WEST SUSSEX COUNTY COUNCIL CONSULTATION

TO:	Arun District Council FAO: David Spring
FROM:	WSCC - Highways Authority
DATE:	24 April 2020
LOCATION:	Ground Floor, Saltmarsh House, 1 Old Market Lane, Littlehampton, BN17 5FB
SUBJECT:	LU/45/20/PL Change of use of existing ground floor retail unit (B1 Business) to 3 No. flats (C3 Dwelling houses).
DATE OF SITE VISIT:	N/A
RECOMMENDATION:	Advice
S106 CONTRIBUTION TOTAL:	N/A

Proposed Ground Floor / Block Plan

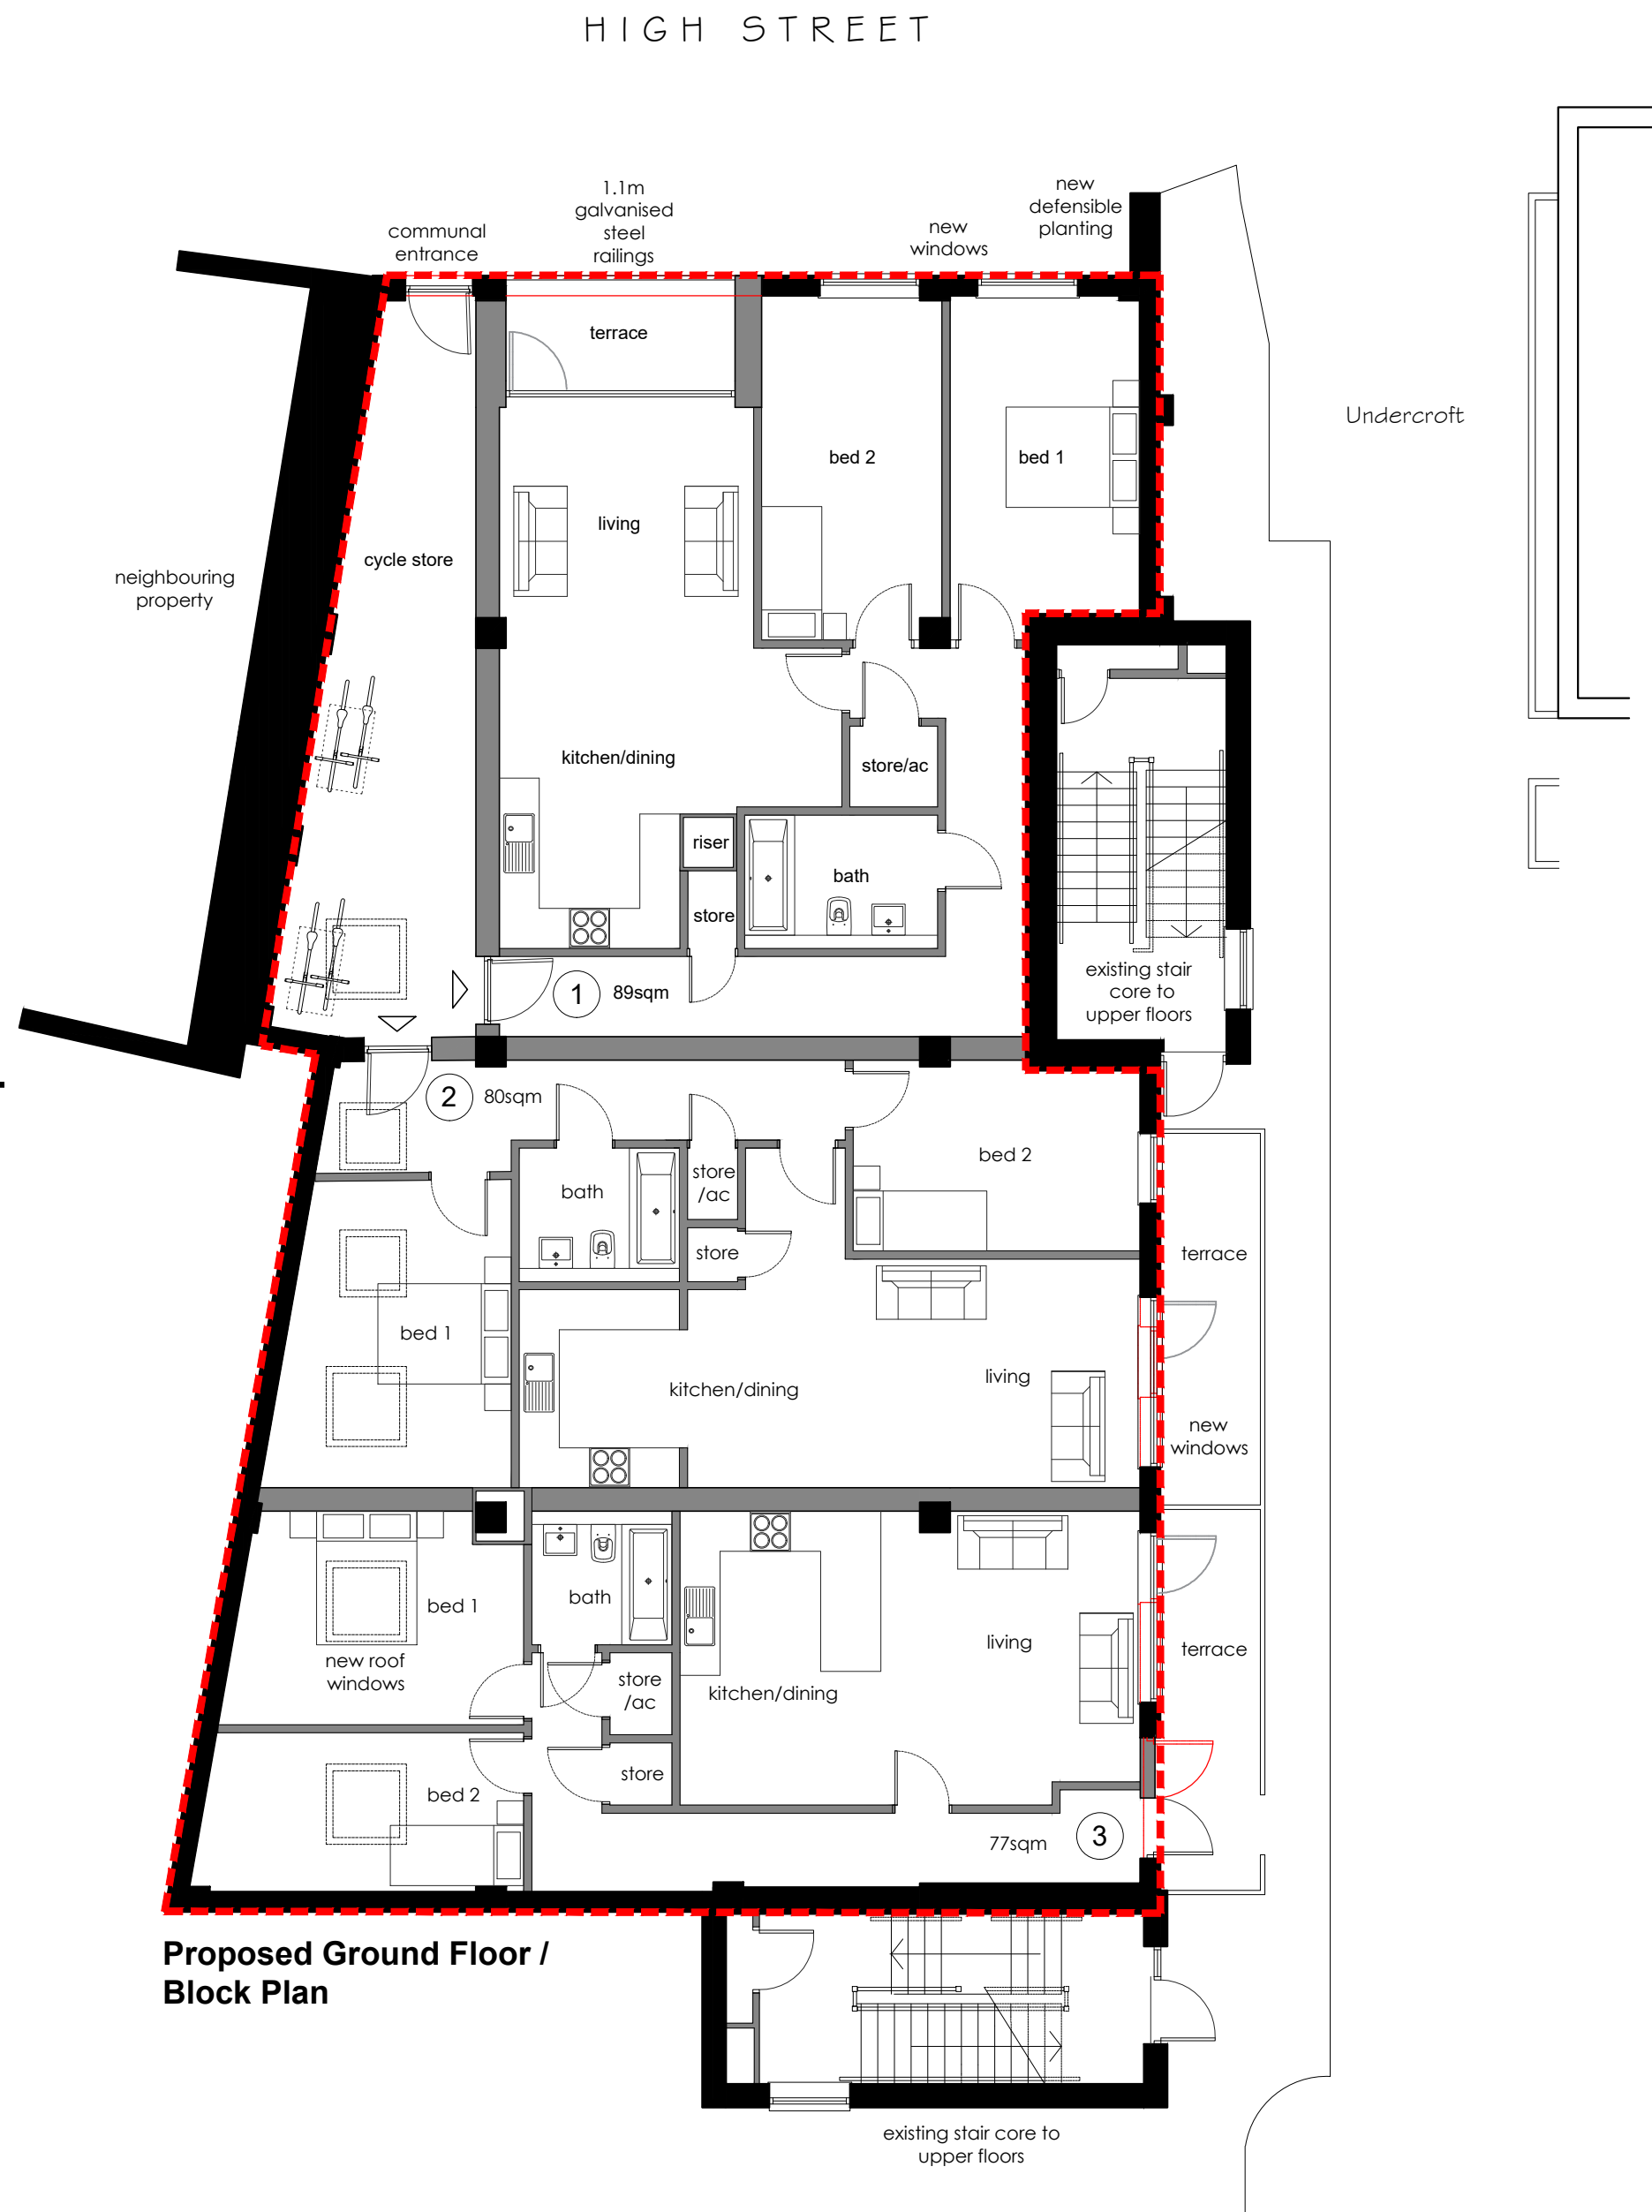
The applicant has not demonstrated vehicular parking provision. The WSCC Car Parking Demand Calculator has indicated that the three flats would create a parking demand for four parking spaces. Whilst on-street parking is limited in the immediate vicinity, there are comprehensive parking restrictions in place prohibiting vehicles from parking in places that would be a detriment to highways safety. The planning authority should consider the potential amenity impacts that may arise from a small increase in on-street parking demand. The LHA notes that the existing use would generate a higher parking demand but has operated safely with a nil car parking provision.

The applicant has demonstrated a communal cycle parking area to the west of the site. Under WSCC parking standards, a development of this size should provide cycle parking for at least three cycles. Cycling is a viable option in the area. The inclusion of secure and covered cycle parking will promote the use of sustainable alternative modes of transport to the private car.

No part of the development shall be first occupied until covered and secure cycle parking spaces have been provided in accordance with plans and details submitted to and approved by the Local Planning Authority.
